Arun District Council
Arun Civic Centre
Maltravers Road
Littlehampton
West Sussex BN17 5LF
Planning & Building Control General Enquiries
Tel: (01903) 737756 Fax: (01903) 730442
Dx: 57406 Littlehampton
Minicom: 01903 732765
e-mail: planning@arun.gov.uk
website: www.arun.gov.uk/planning

Application No: A/193/20/PL
Site Address: Ham Manor Cottage Ham Manor Way Angmering BN16 4JQ
Description of works: Erection of a 1 No. 3 bedroom chalet bungalow & detached garage. This site is in CiL Zone 3 and is CIL Liable as dwelling.

Proposed Street Scene (Scale 1:200)

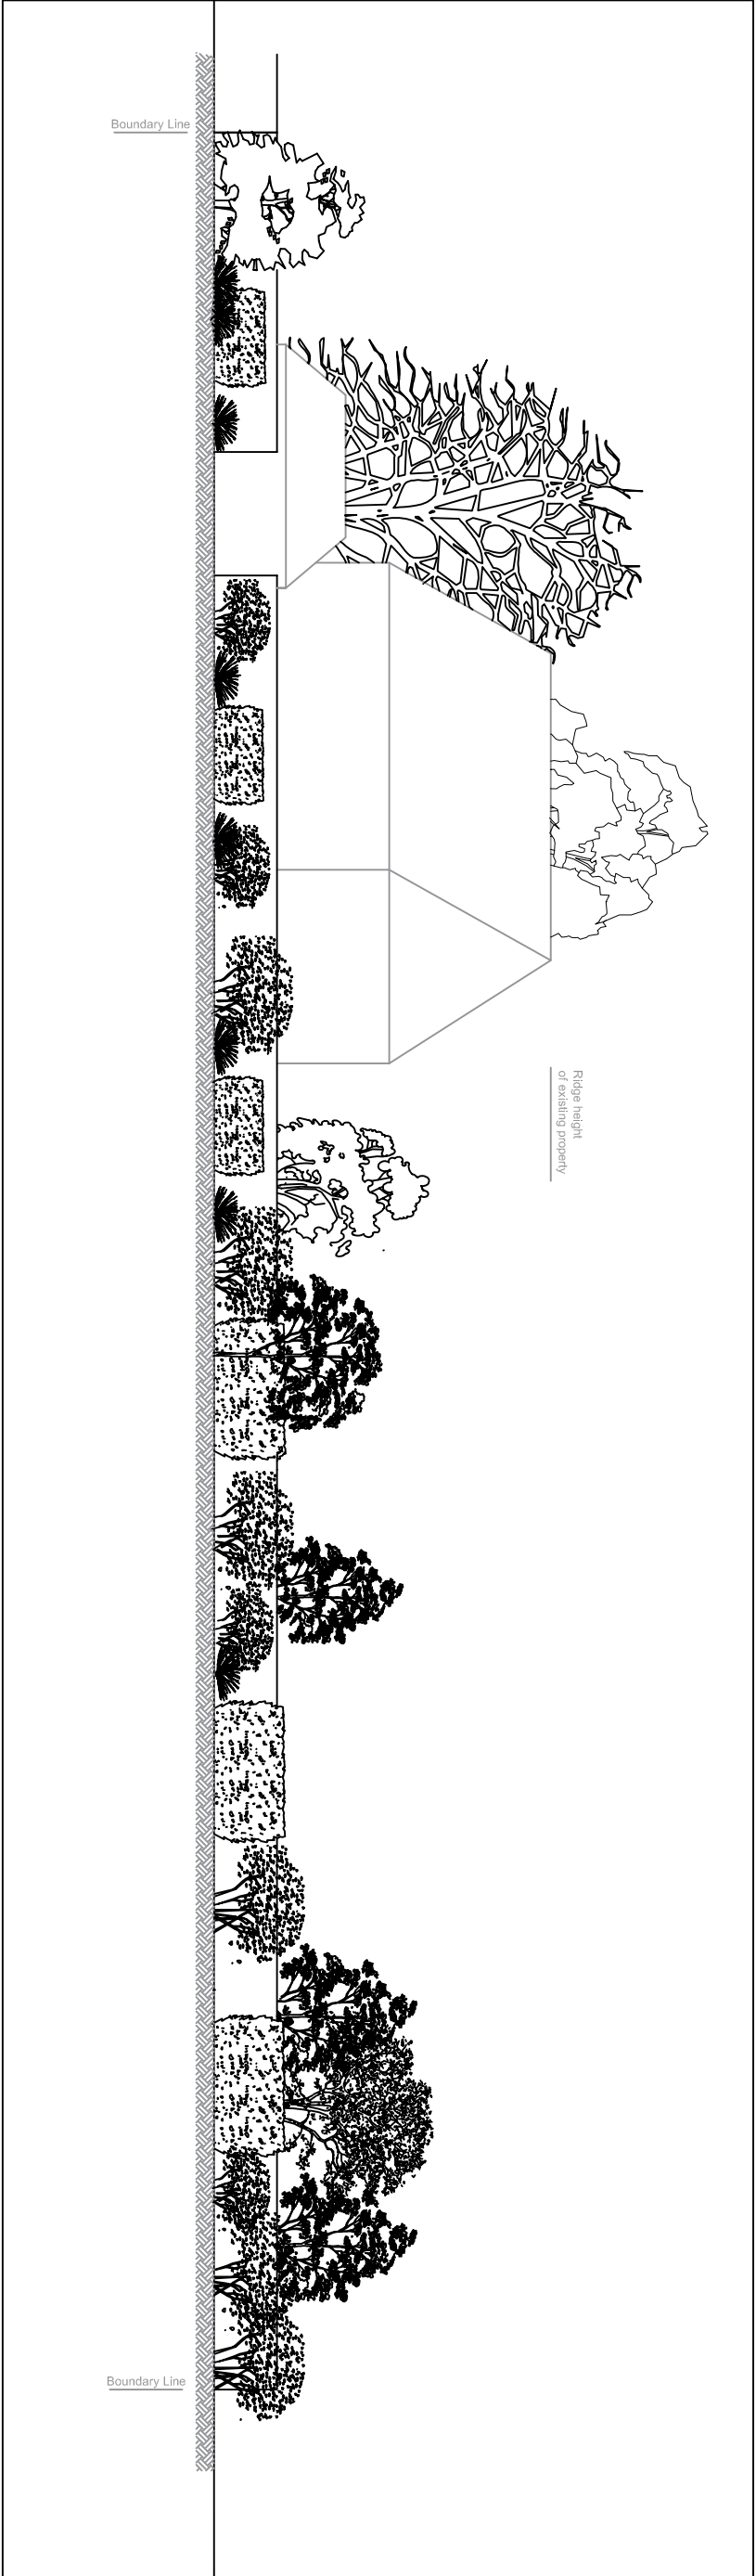
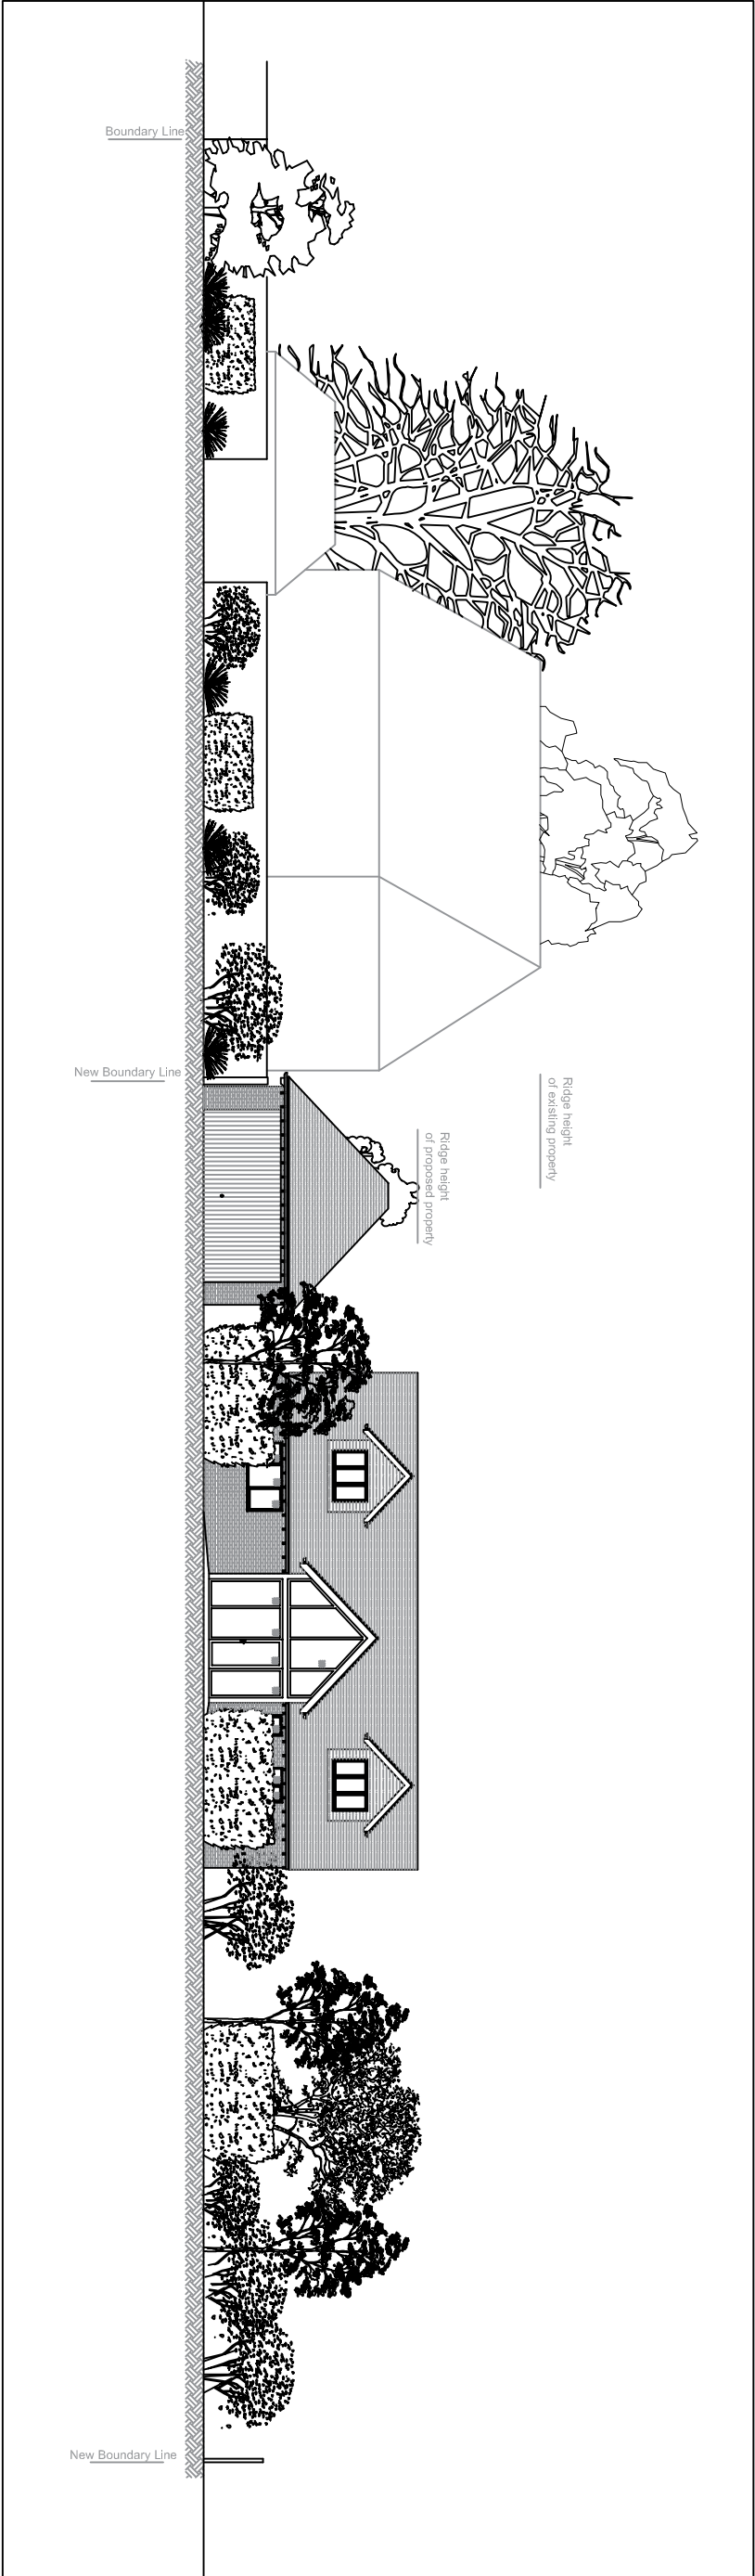
The development architectural drawings show that this proposed property would be in front of the existing building line. In my opinion the plot size is not large enough for this dwelling. It would be detrimental to the existing road layout with loss of trees and privacy to other properties.
